RE: The Springs Of Ballentine

*40 Rawls Club Road
Fuquay-Varina, NC
Mr. Taylor,*

The following is a response letter for the above referenced projects review comments of May 09, 2023.

CEILING LEVEL PIPING PLAN A  
0-1/8" = 1 Foot

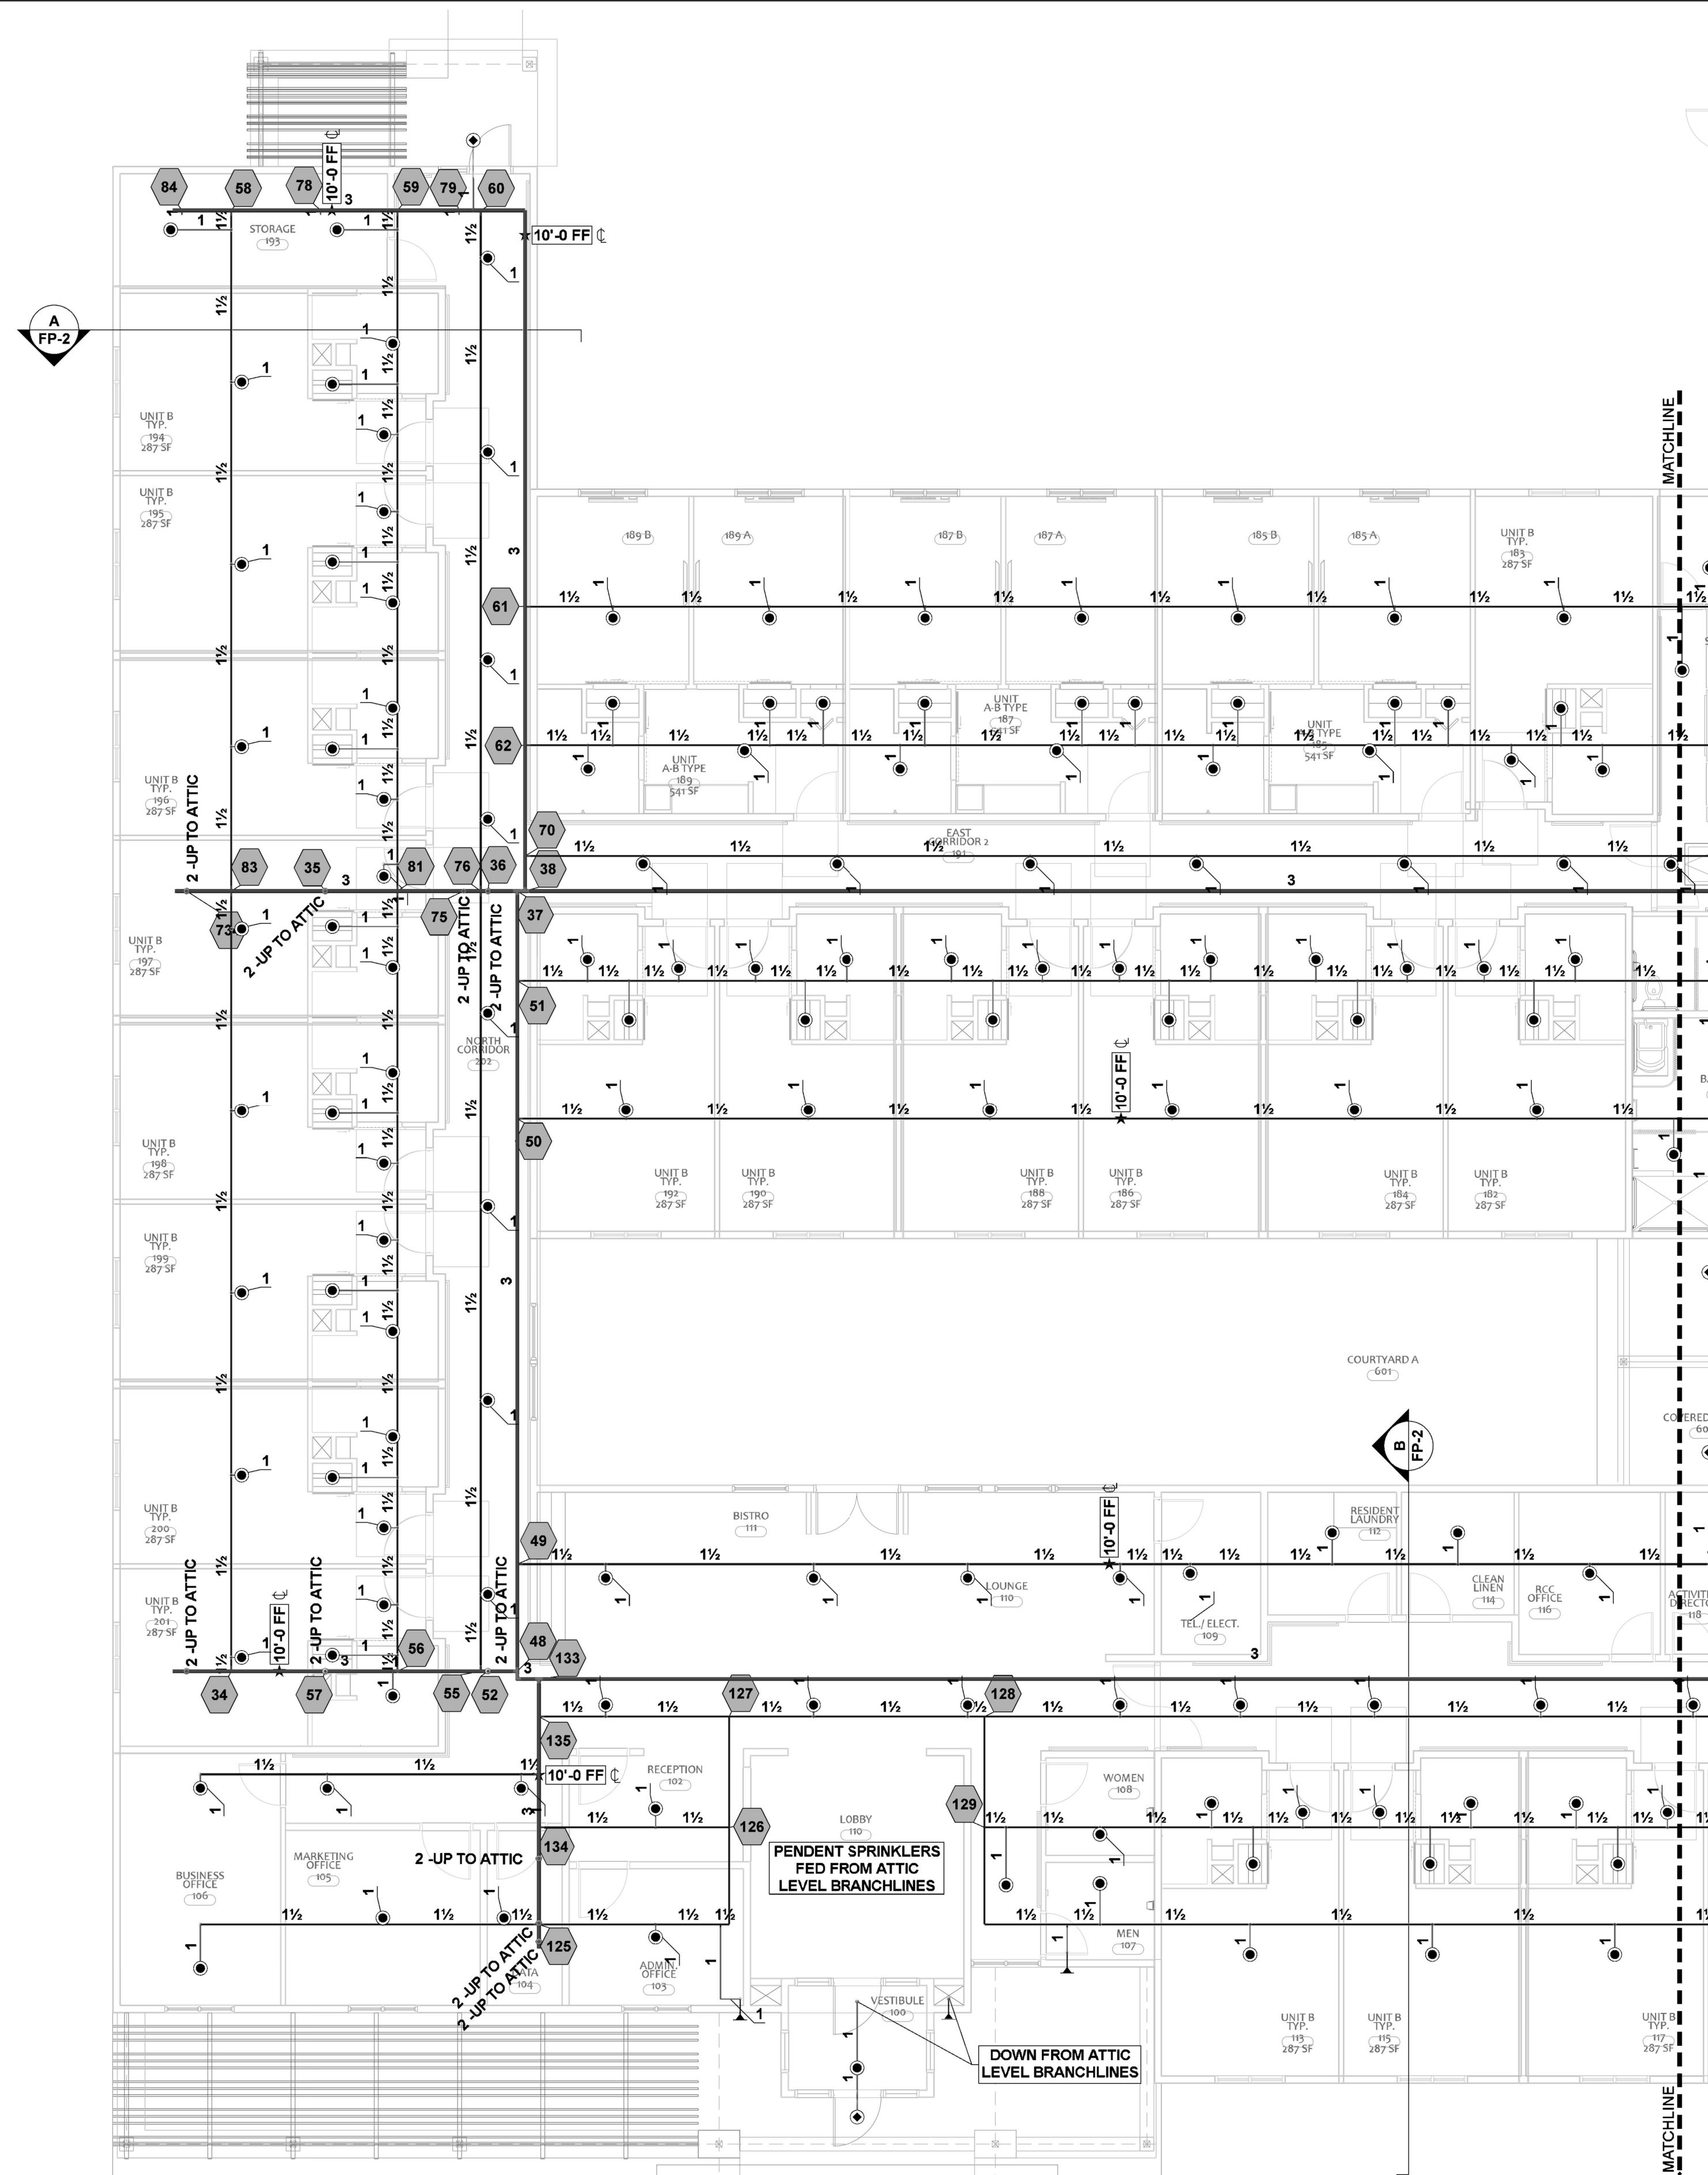
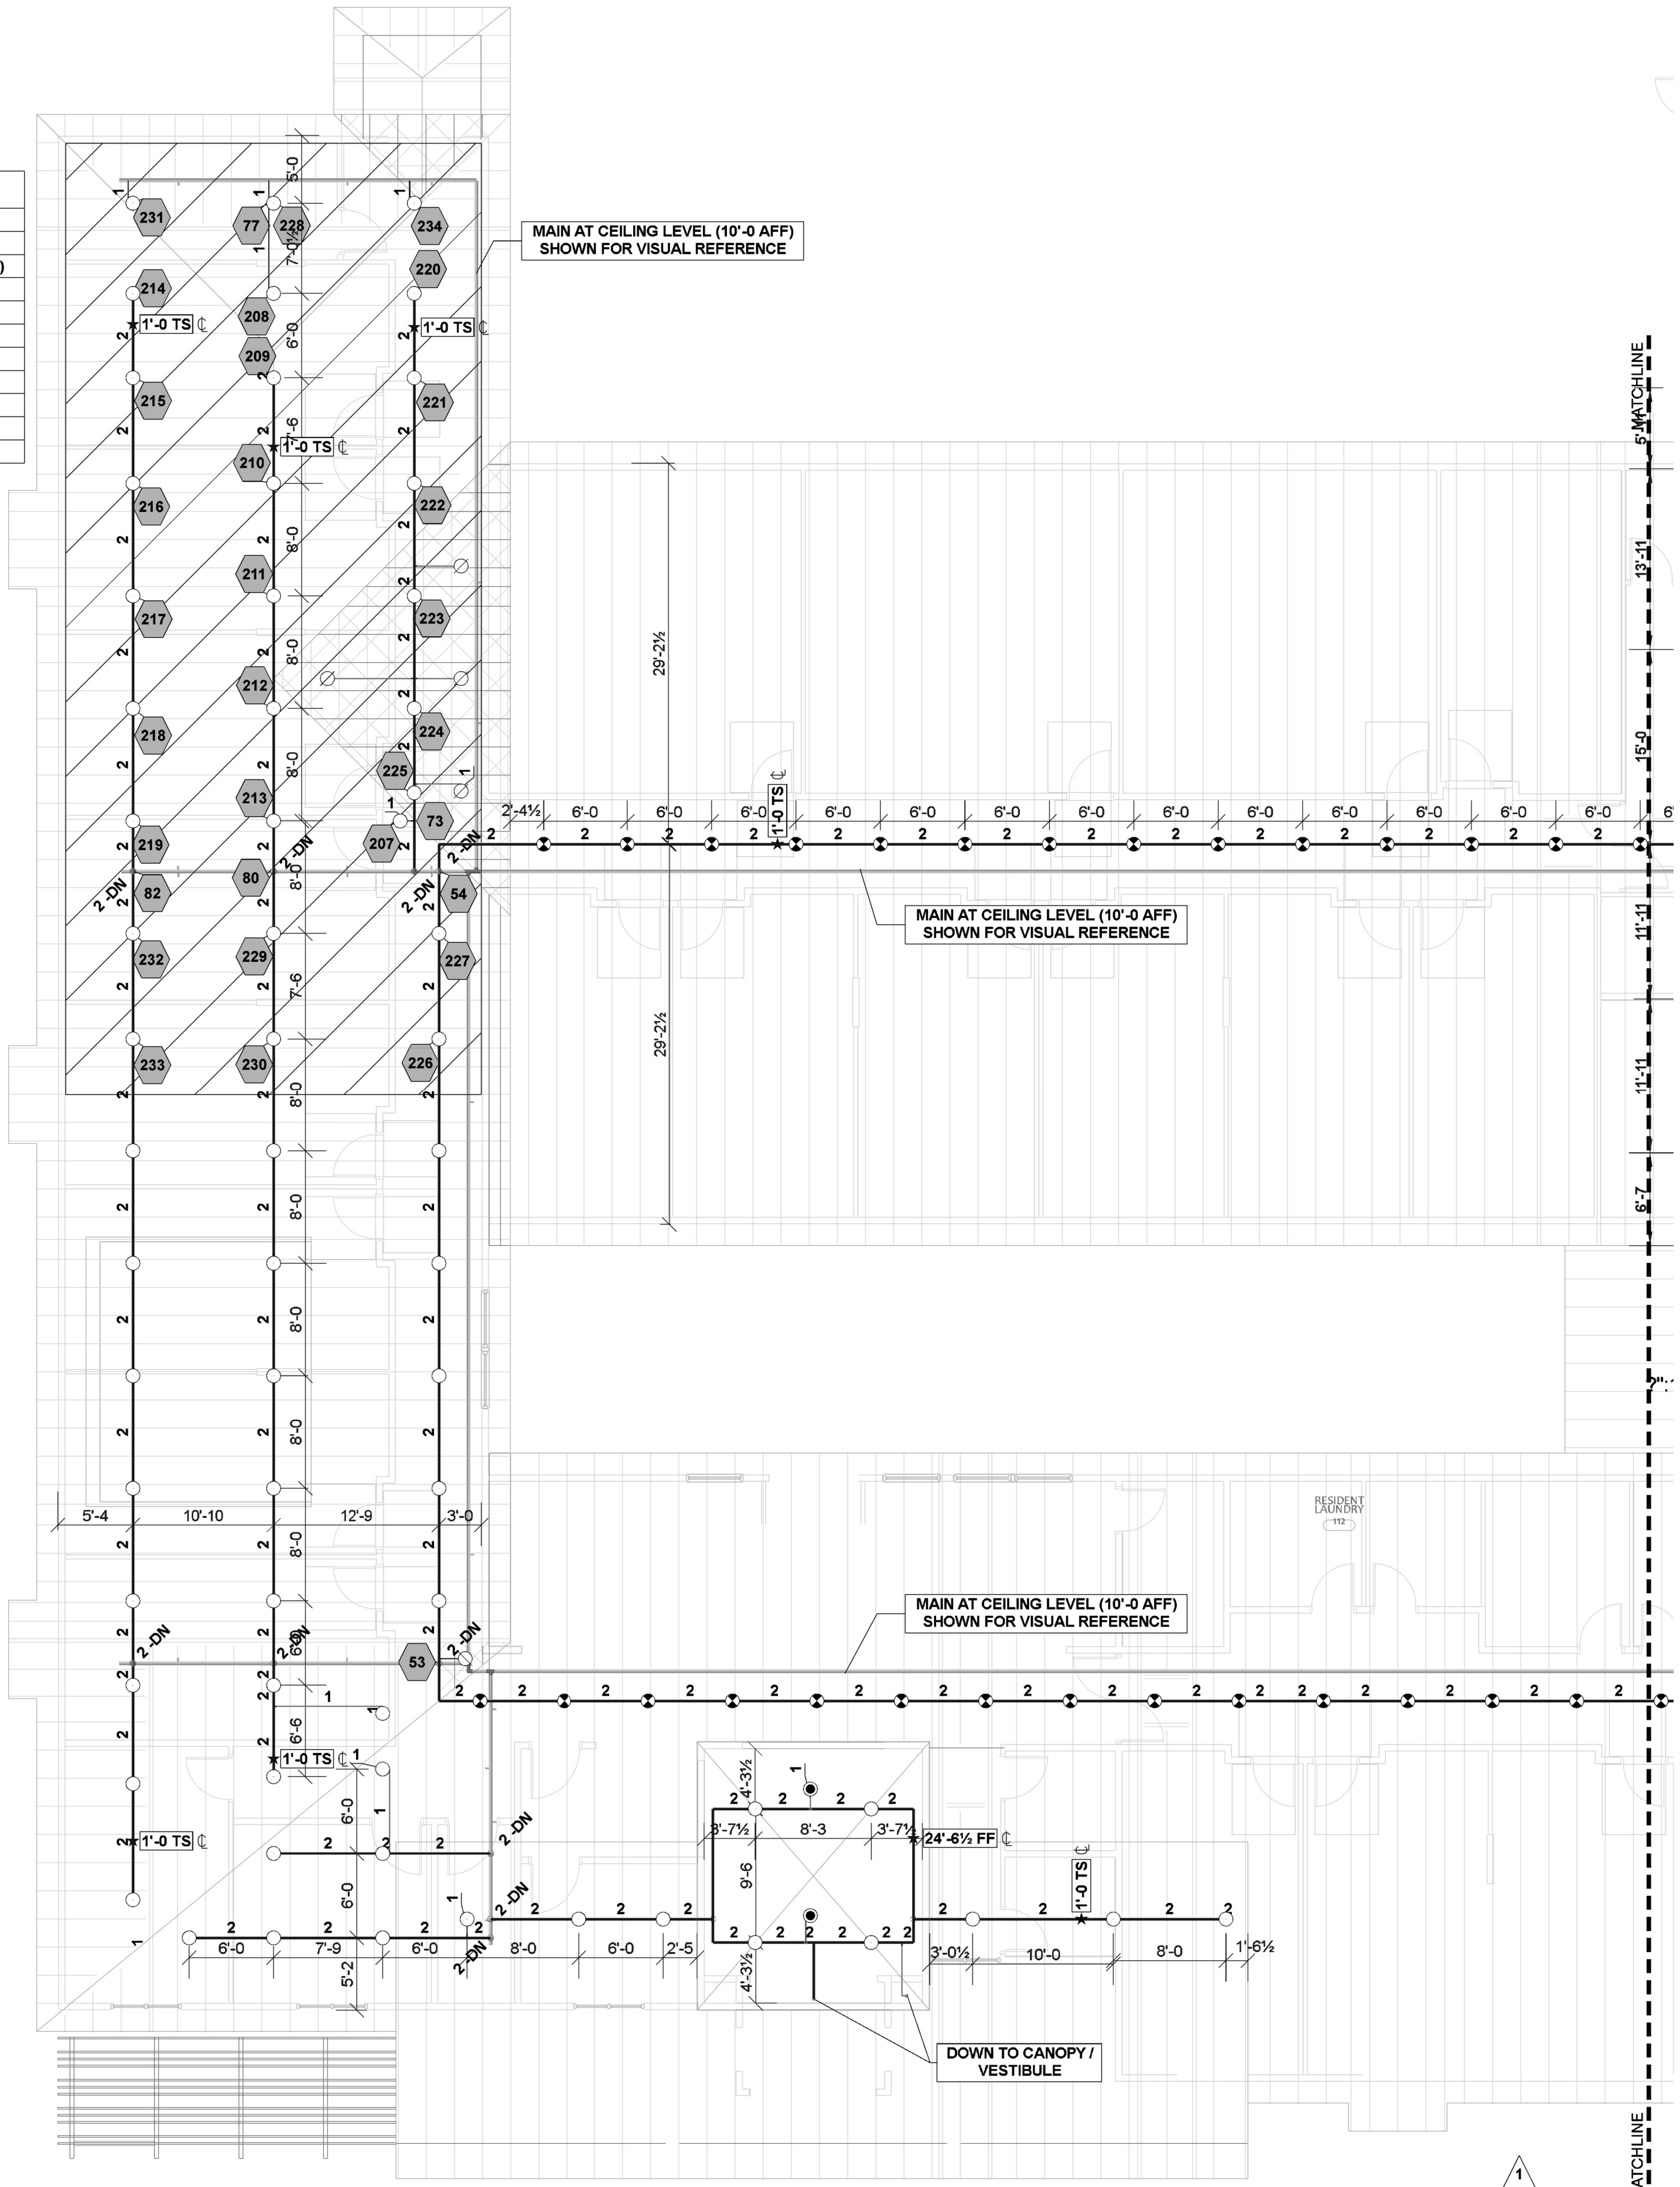
Comment 1: Point of compass is required per NFPA 13, Chapter 23, section 23.1.3 #3.
Response 1: Point of compass has been added to Site Plan on FP-1.

Comment 4: City main in street and whether dead end or circulating if dead end, direction and distance to nearest circulating main and city main test results and system elevation relative to test hydrant per NFPA 13, Chapter 23, Section 23.1.3 #10.
Response 4: City main circulates with Hwy 401 UG Main & Rawls Church Rd UG Main. Lengths to circulating mains are now noted on Site Plan on FP-1 as well as elevations relative to Sea Level. Labels noting the Test & Flow Hydrants utilized during J&D Sprinklers water test have been added.

OFFICE: 919.553.2356 FAX: 919.359.0622

Comment 7. The sprinkler head outside rear entry near Electrical Room 169 appears to not be the correct symbol for the intended head.

Comment 10. Show location of the inspectors test valve on the plan view.

Comment 11. Provide cut sheets & location for alarm bells per NFPA 13, Chapter 23, section 23.1.3 #26.

Response 7. Sprinkler head symbol has been corrected to reflect a Dry Flex Pendant Sprinkler (V3506).

Response 10. Location of Inspectors test valve now shown in Mech Room 168 (Riser Room).

Response. Spec sheets are now included in submittal package. Alarm bell now reflected on page FP-1 in Riser Detail & outside Mech Room 168 (Riser Room).

Response. Hydrant size, location, number of outlets & role in water test is now noted on page FP-1 under Site Plan.
